Rampion 2 Offshore Wind Farm (Project Reference: EN010117)

Deadline 4 Submission (3 June 2024)

West Sussex County Council (IP Reference 200445228)

**Eastern boundary with Kent Street Lane (C-C)**

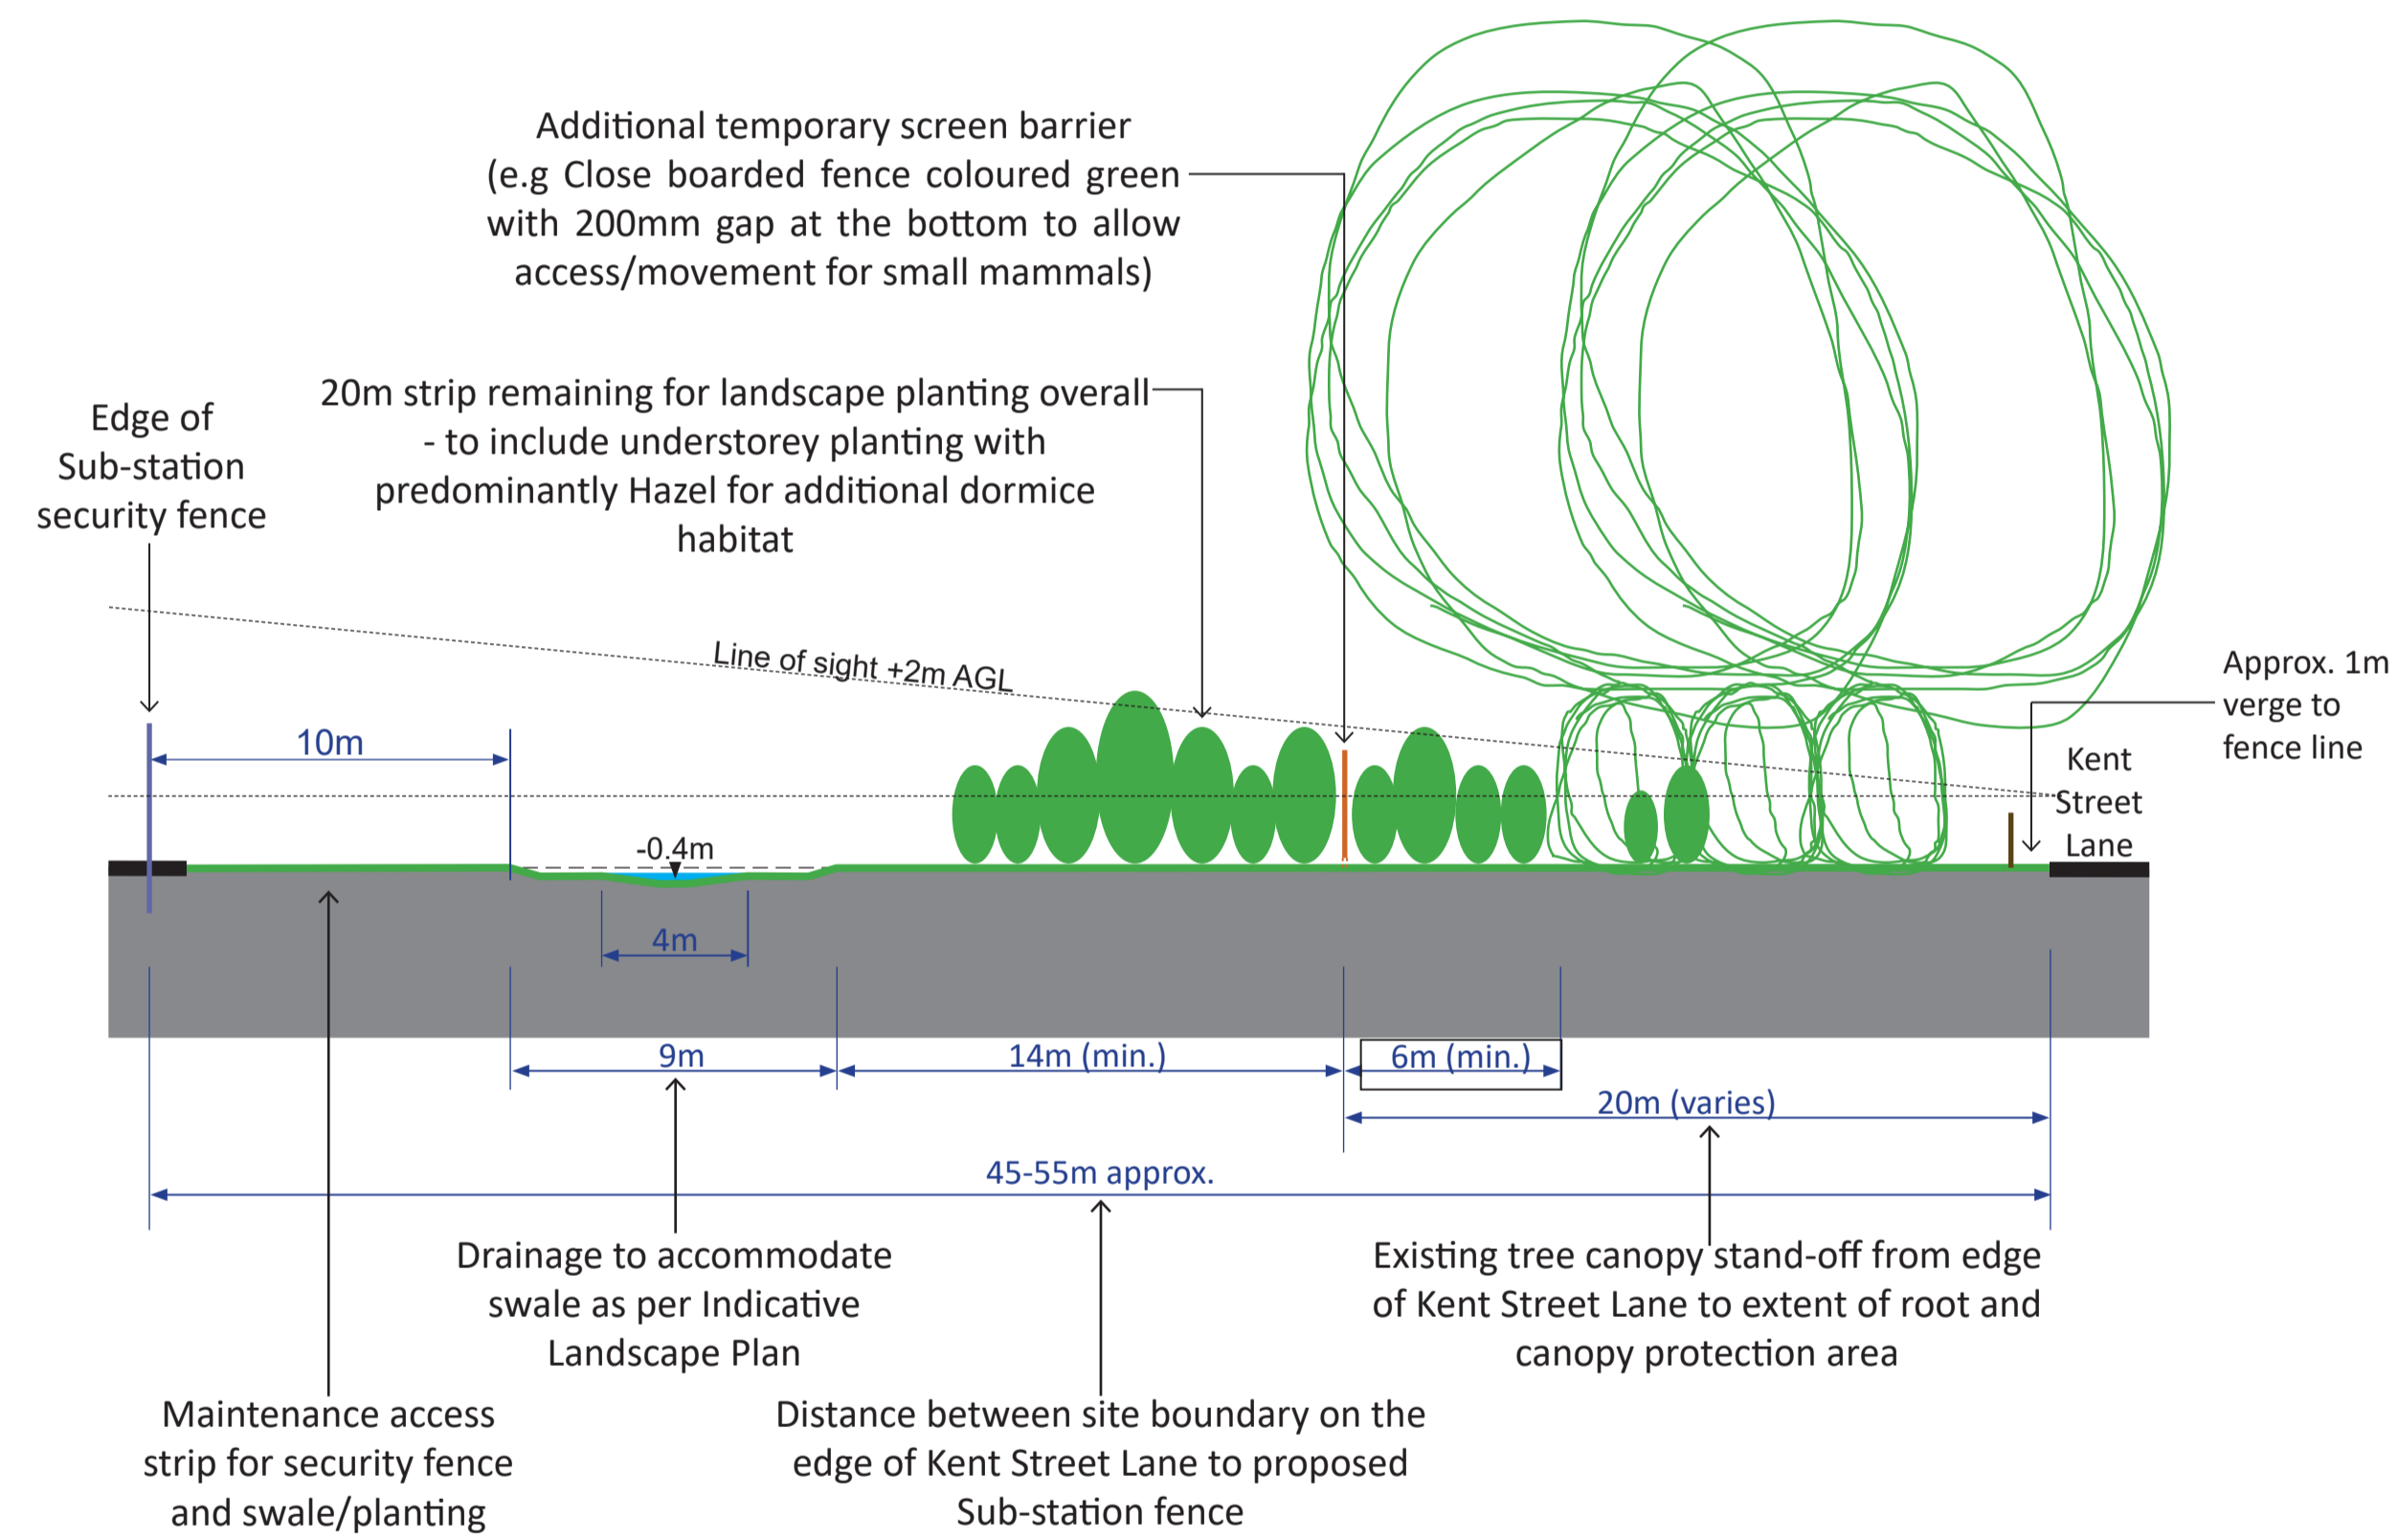
- Regarding the updated Oakendene Substation Indicative Landscape Plan, the additional planting/updated planting provision is welcomed (e.g. at the access and to the south west corner). However, it is somewhat concerning that the native woodland planting belt along the east of the site (adjacent to Kent Street) seems to be narrower, which could potentially reduce its screening effect. Further along this boundary, the plan notes '*Retained and protected tree cover along Kent Street Lane*', however, this seemingly conflicts with the latest VRPs in the OCoCP, which show this as a hedgerow '*cleared to 20m*' – this is of concern given the screening effect of the mature existing boundary.
